Department of Public Works

Preliminary Acceptance Punch List Bent Grass Meadows Drive/Woodmen Frontage Road

7/25/2024

Bent Grass Meadows Drive/Woodmen Frontage Road
Per Approved Plans
7/25/2024

| [Pattern] | EXISTING LOT # |

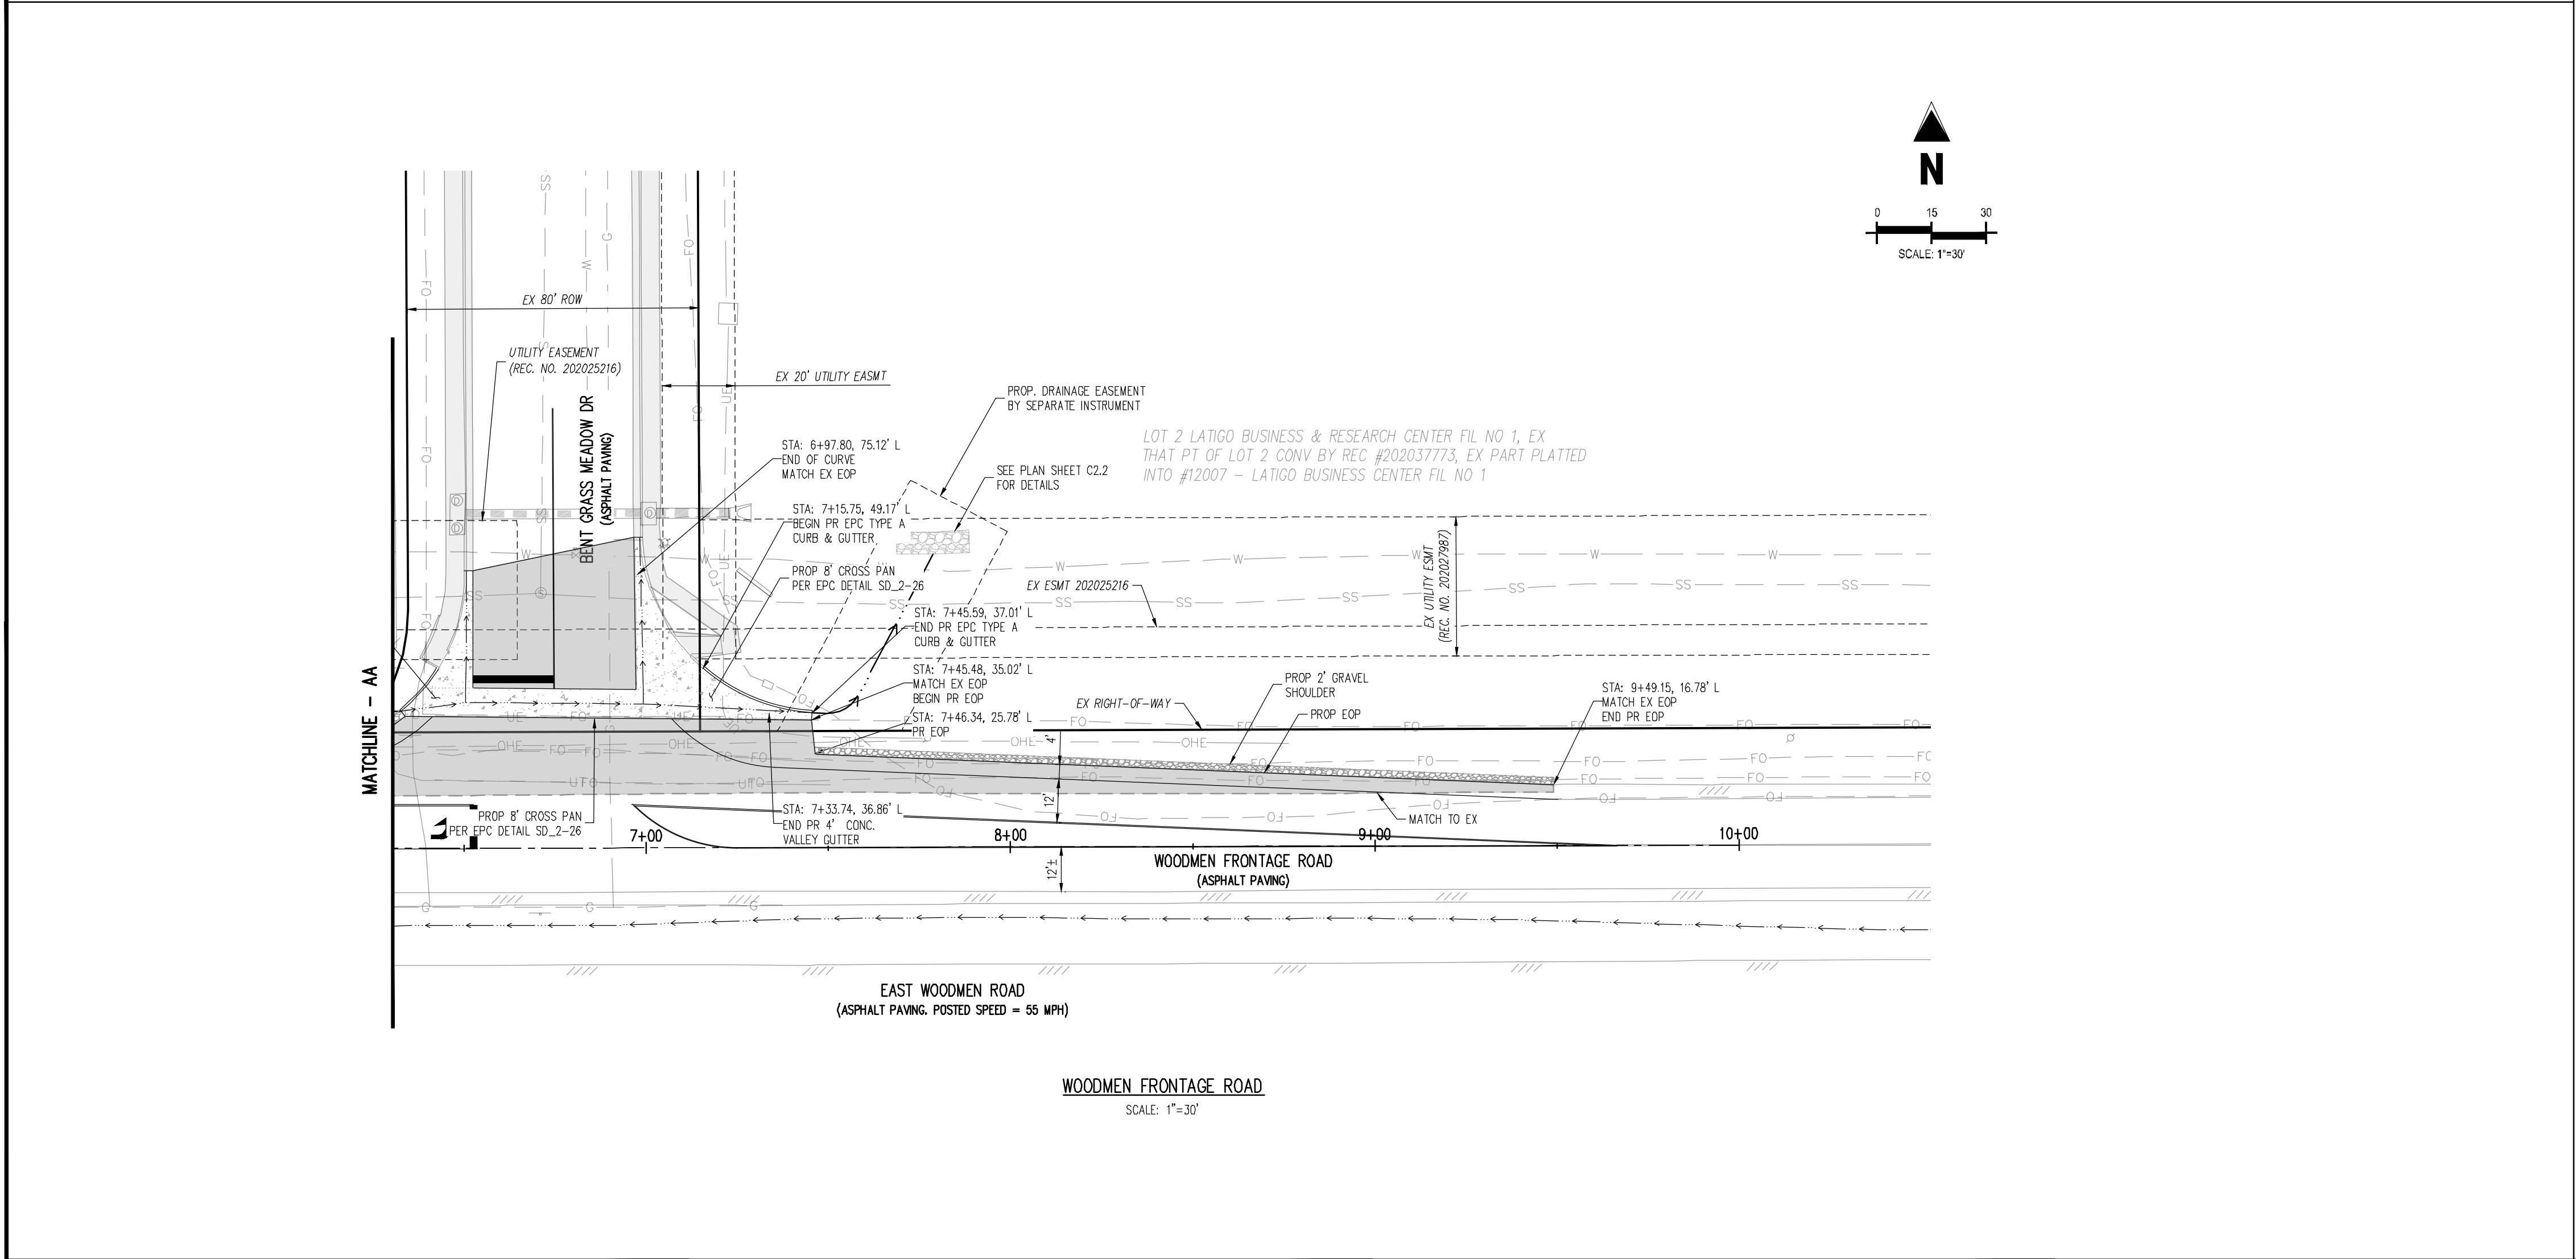
- Cut swale on far west driveway on the west side.
- Clean site (stakes, trash...)
- Relocate stop sign on Bent Grass Meadow Dr and frontage intersection as called out on Construction Drawing C1.1
